DAVID EVANS
AND ASSOCIATES INC.

SUBJECT: Ogden Point Short Plat: Comment Response Letter

Thank you for your review of the Ogden point Short Plat. This letter is in response to your revised corrections letter dated August 22, 2019. We have prepared revised documents and included a revised short plat map, site plan, and tree calculations. Staff review comments are listed below in black text, the revised review comment in **red text** and our response to staff comments are provided in **Bold Italics**.

EASEMENTS TO REMAIN IN EFFECT

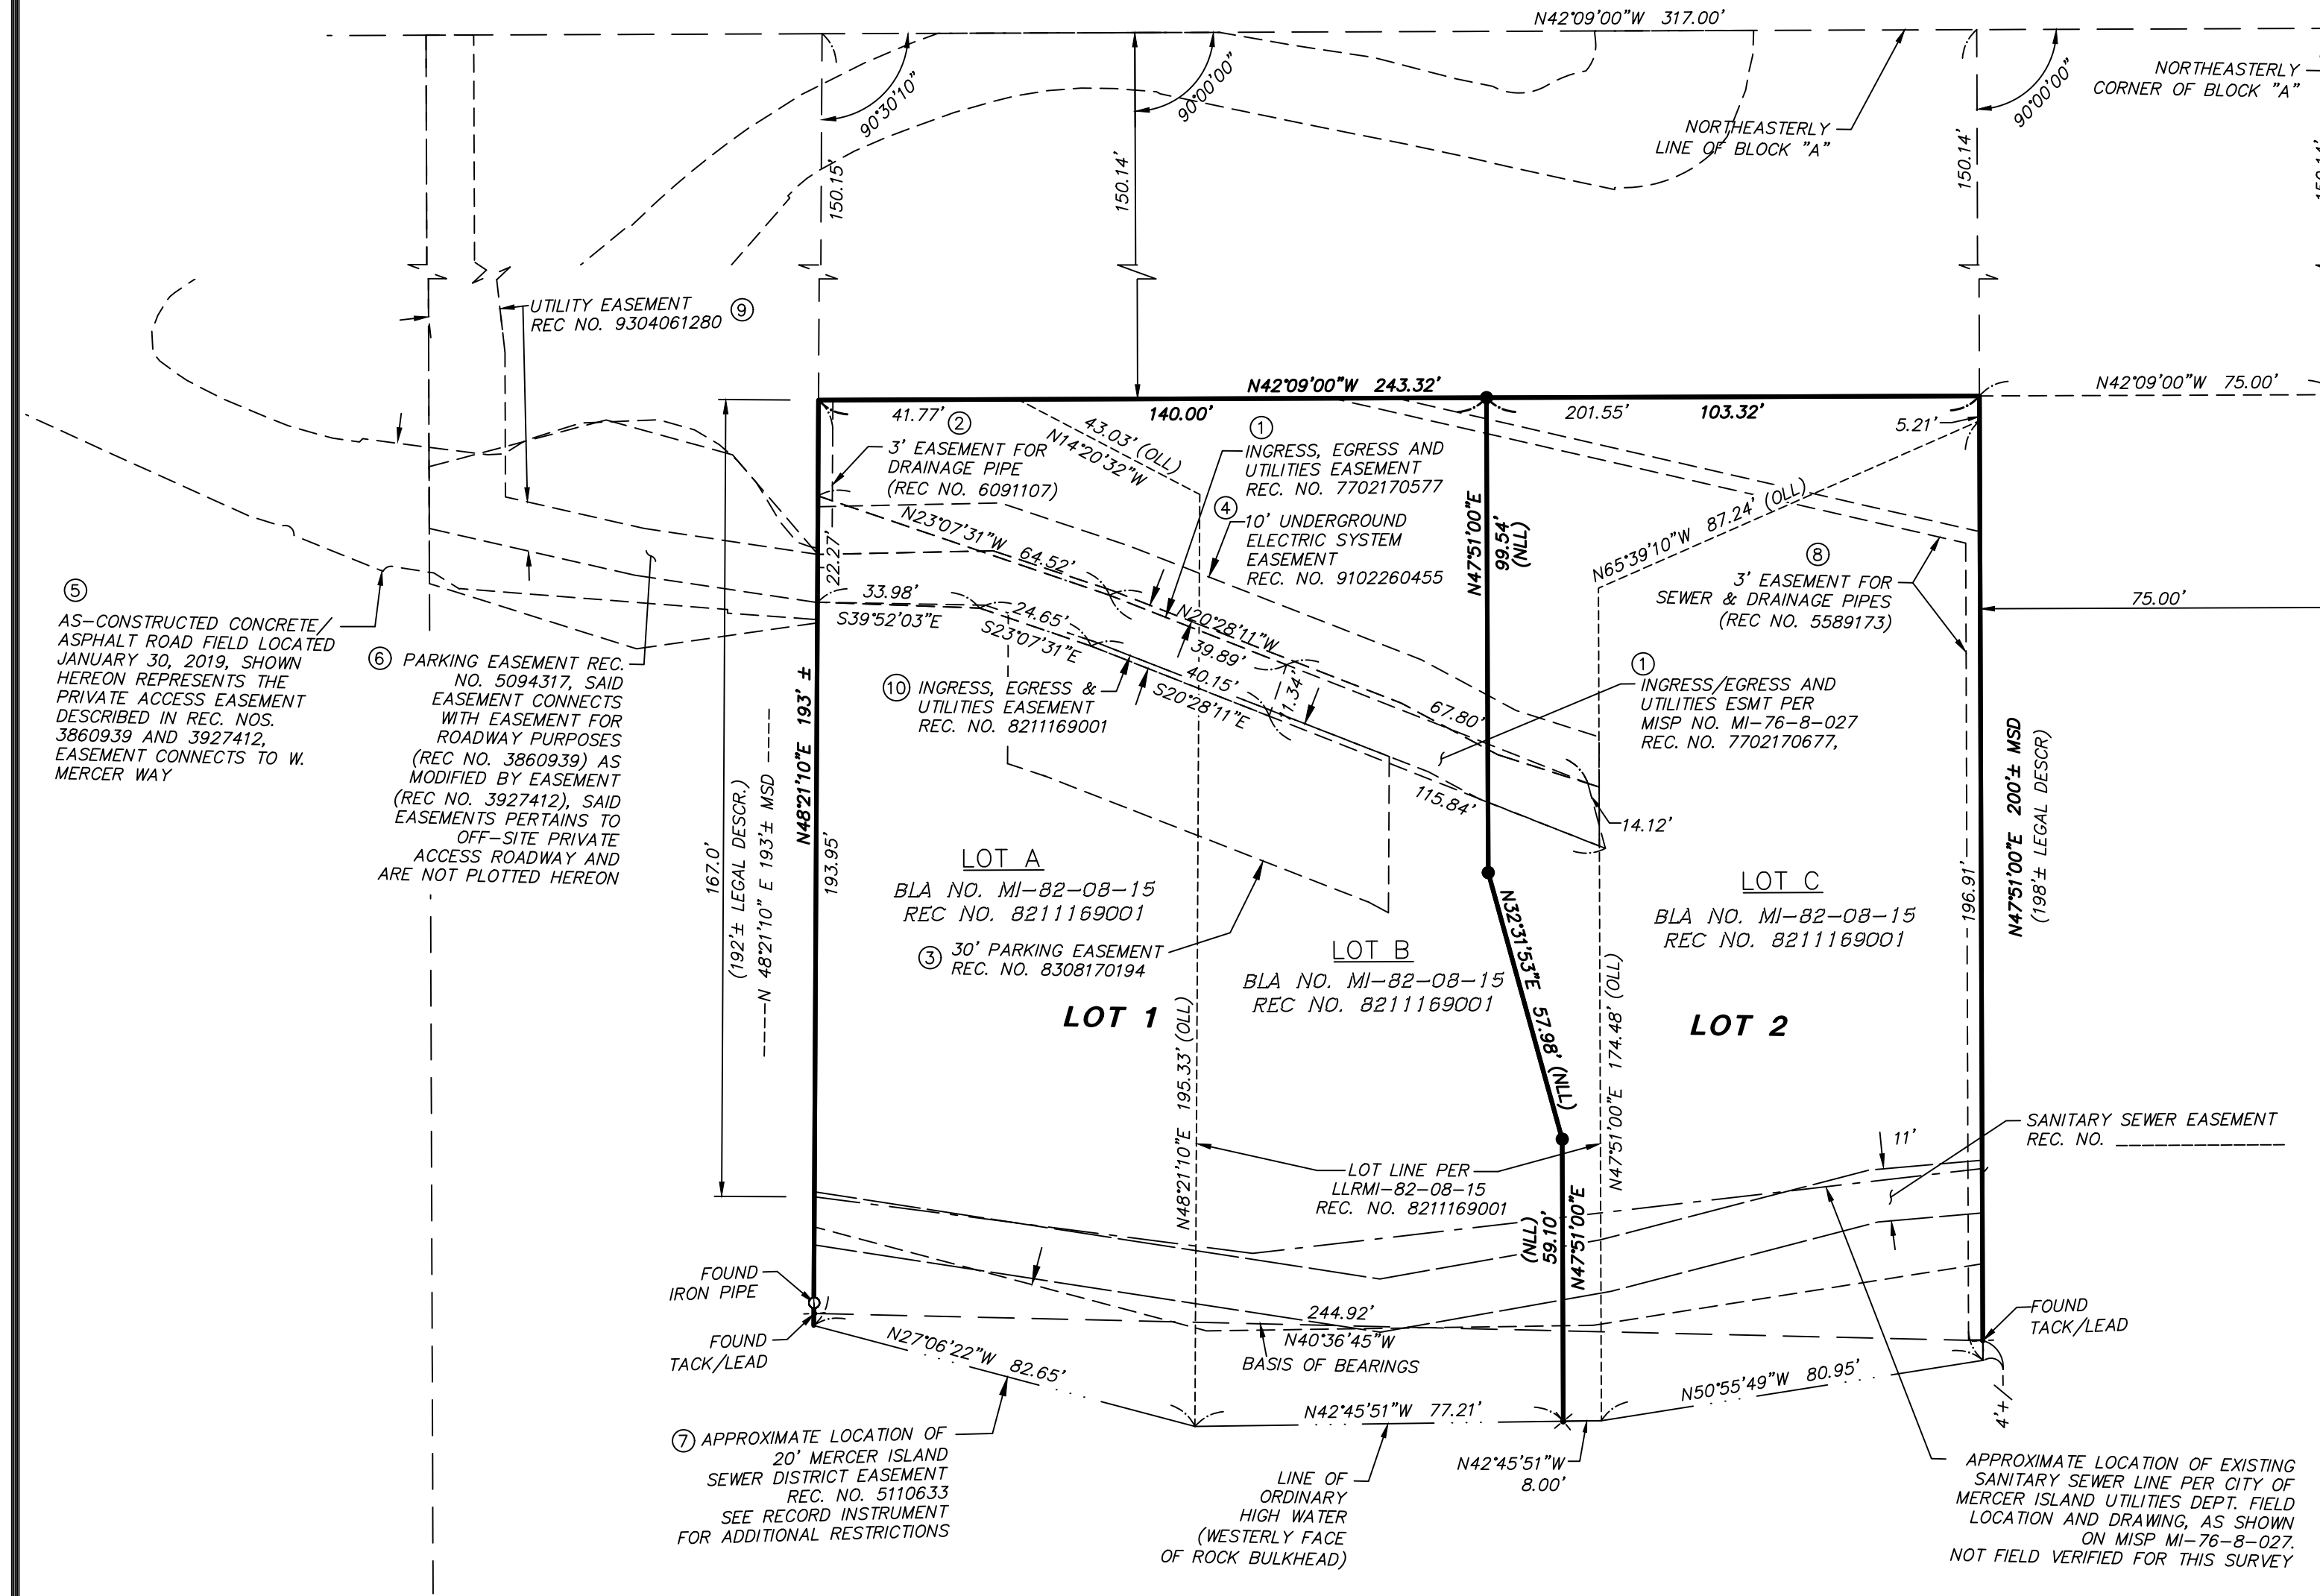
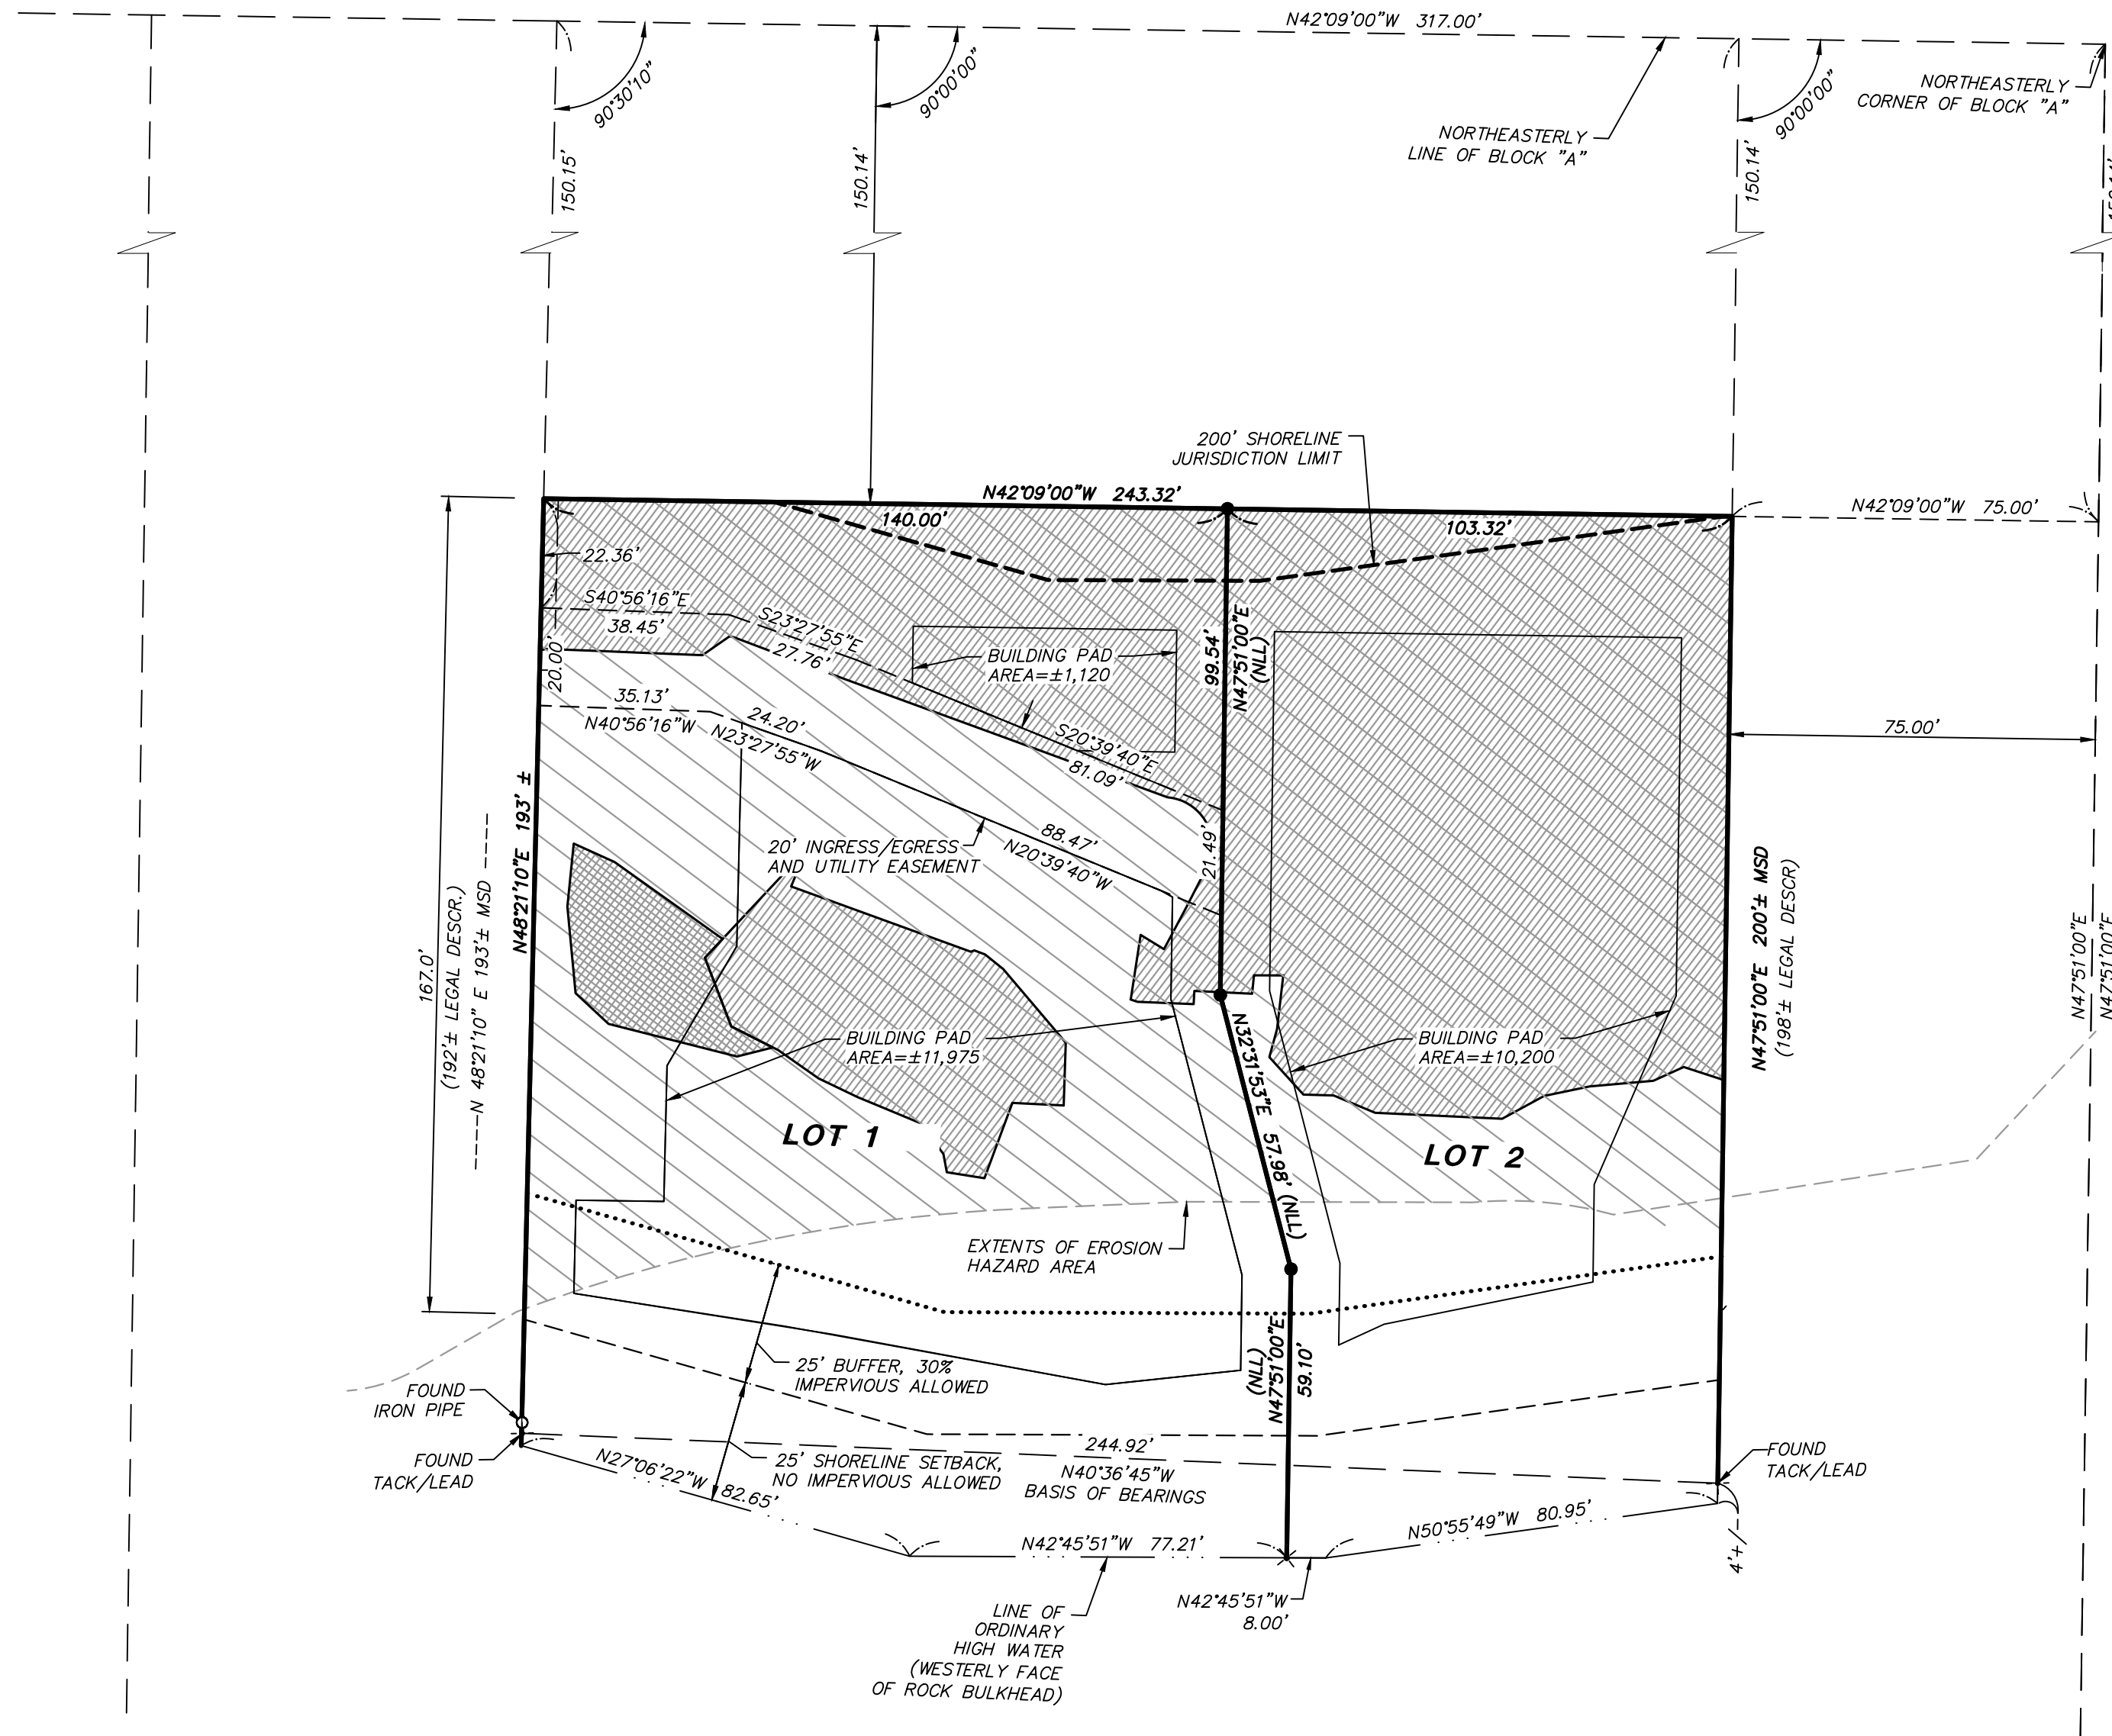
31. Please indicate the existing public sanitary sewer easement on all site plans. All private utilities, such as storm drainage system, irrigation system, dry utilities (power, gas, etc.) shall be located outside the existing public sanitary sewer easement.

The existing sanitary sewer easement cannot be located and plotted due to inconsistencies with its legal description. The existing sewer easement is shown approximately on the short plat map and is proposed to be relinquished with this short plat application. A new proposed sewer easement that encompasses the as-built location of the existing sewer main is proposed as a separate easement document. This easement will be located 5' outside of the two sewer mains. A legal description of this easement has been provided with this resubmittal. The site currently has an irrigation pump system that is located on the lake shore. Irrigation lines must past through the sewer easement but it is understood that proper pipe clearances (3' vertical separation) must be provided and that crossings of the sewer mains should be done perpendicularly where possible. Storm drainage from the site must also pass through the proposed sewer easement in order to outfall at the Lake.
